Application by Highways England for an order granting development consent for the M25 Junction 10/A3 Wisley Interchange improvement project

Submission made pursuant to Deadline 4

This submission comprises responses to Highway England's comments on the Joint Council's Local Impact Report.

Comments on HE response to LIR (REP3-007)

Drawing Title: **LAND PLANS REGULATION 5(2)(i) SHEET 1 OF 31**

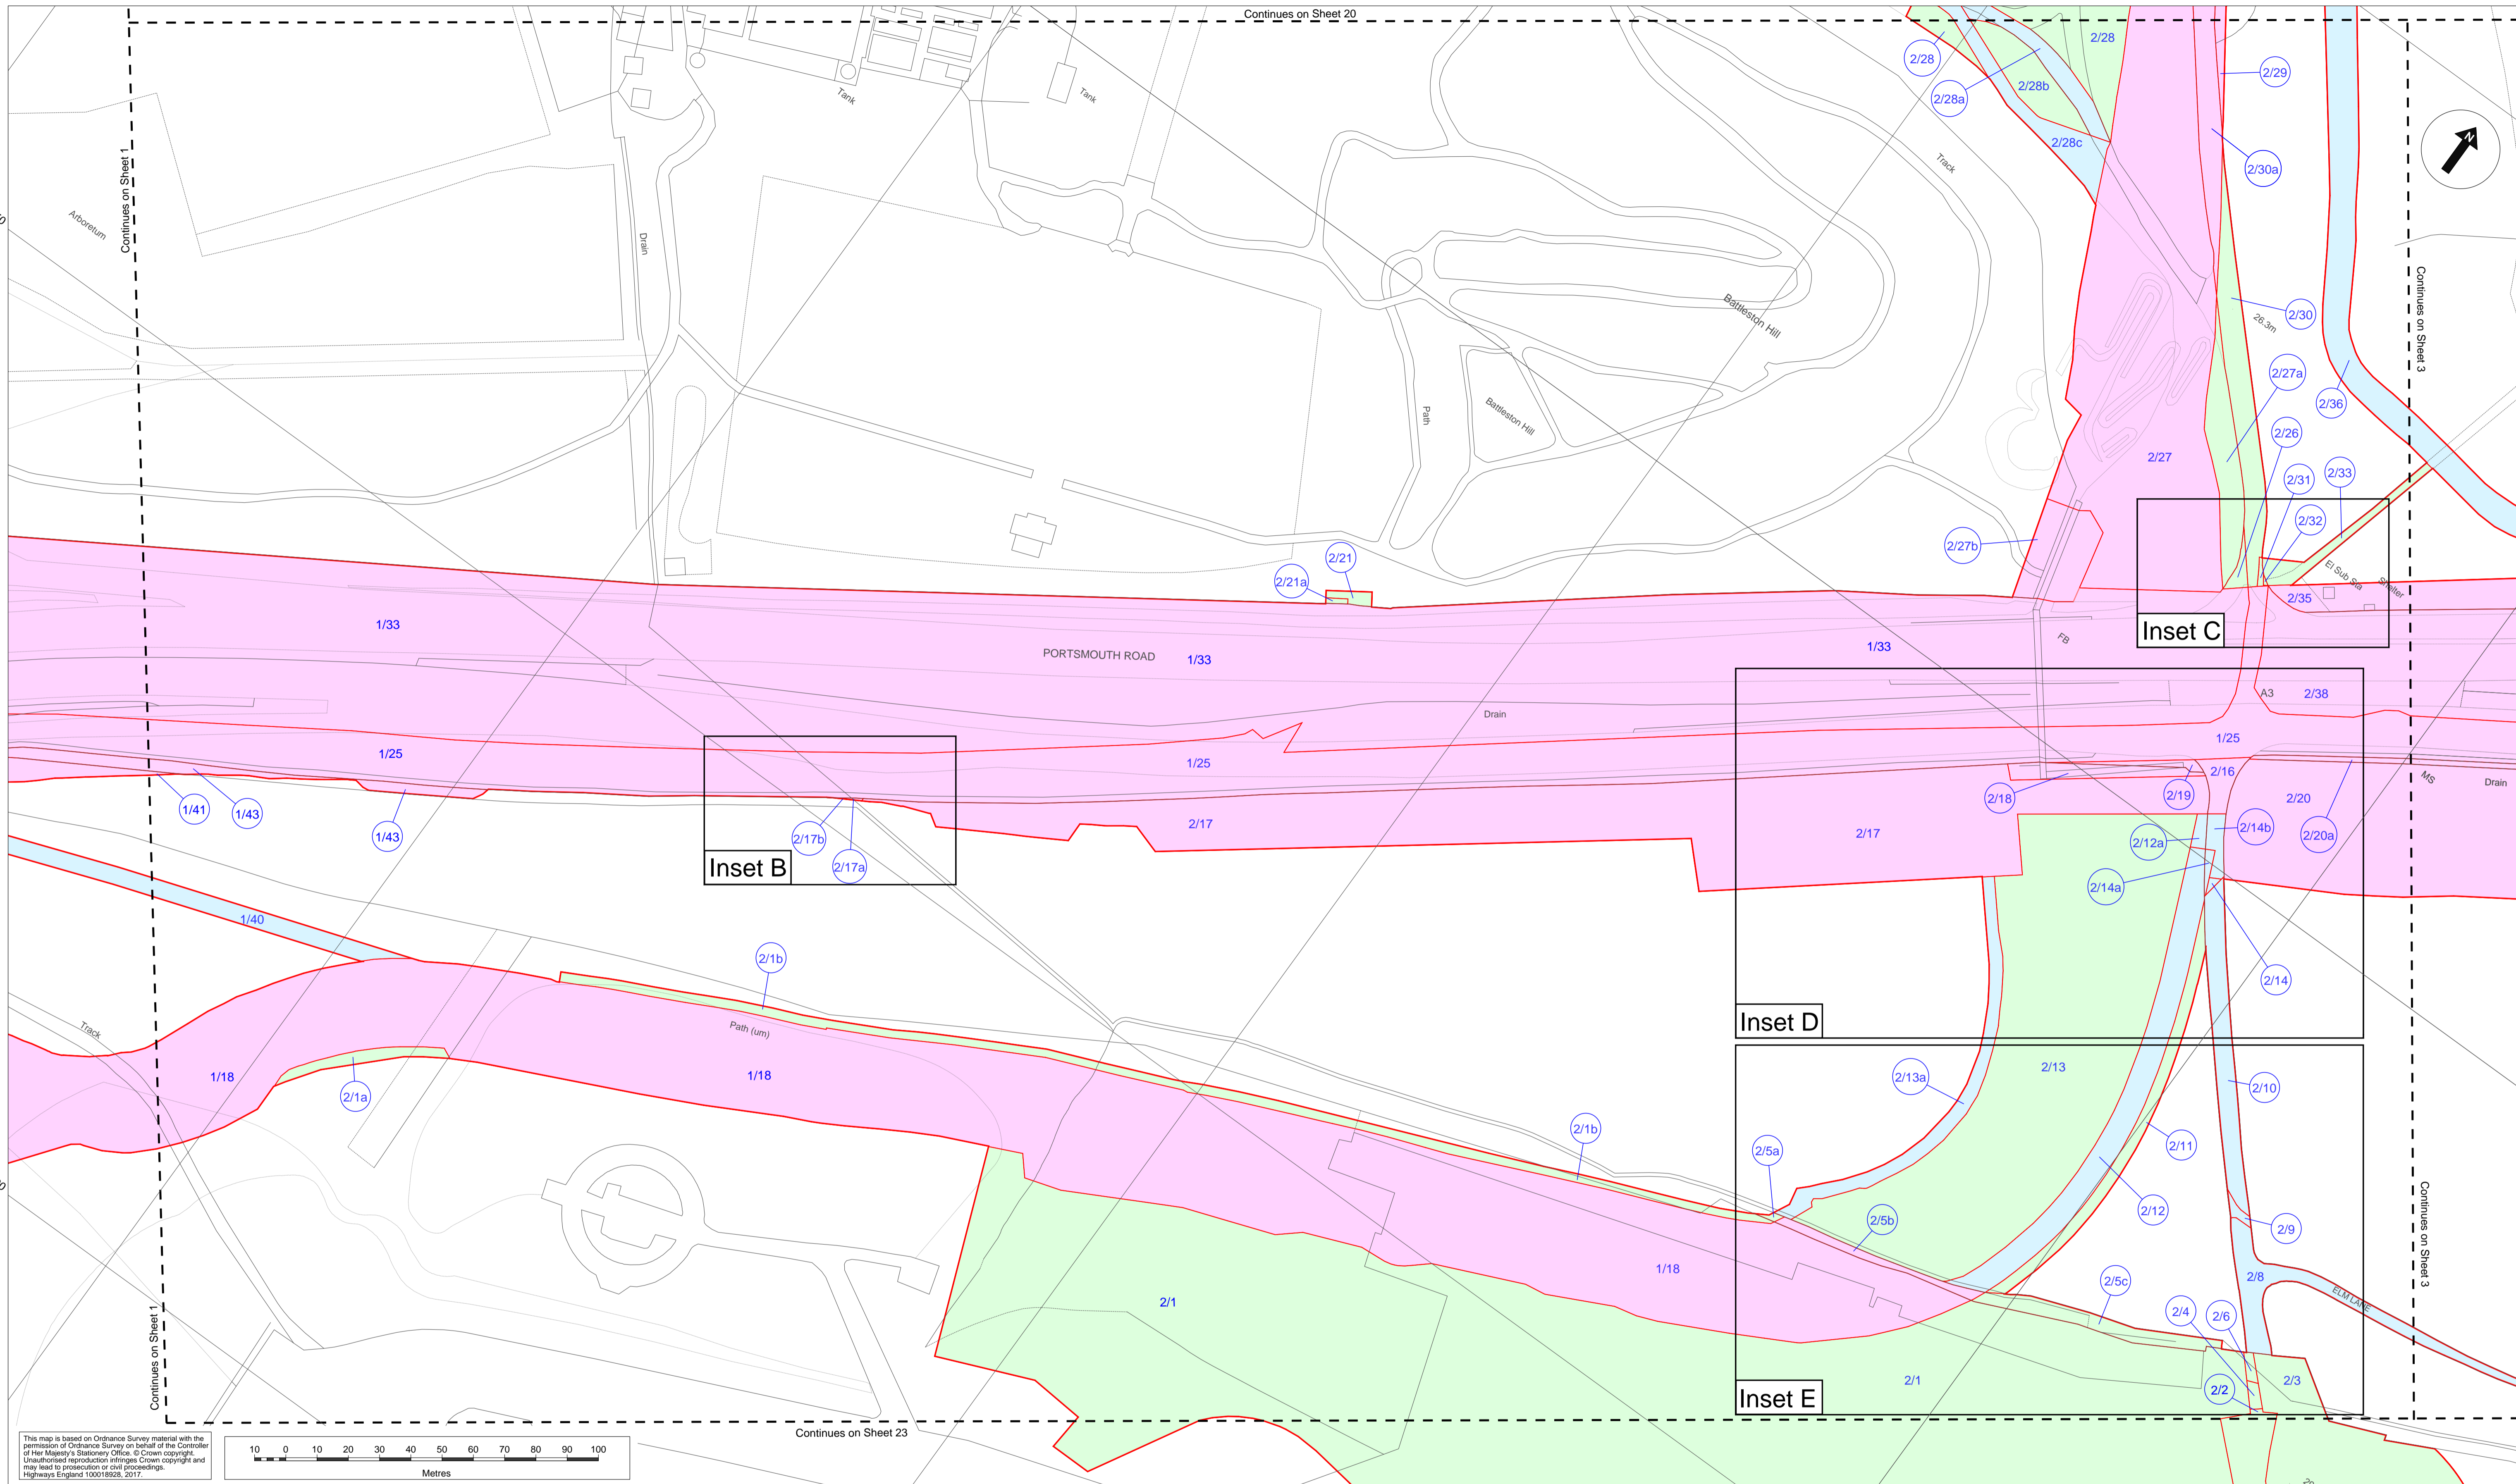
P27. LI1	Enclaves of land left between NMU and A3 carriageway	The proposed HE boundary would be aligned along the A3 side of the NMU route, as a result of which, there will not be any enclaves of different land ownership.	The does not appear to accord with Volume 2.2 Land Plans, eg. sheet 3
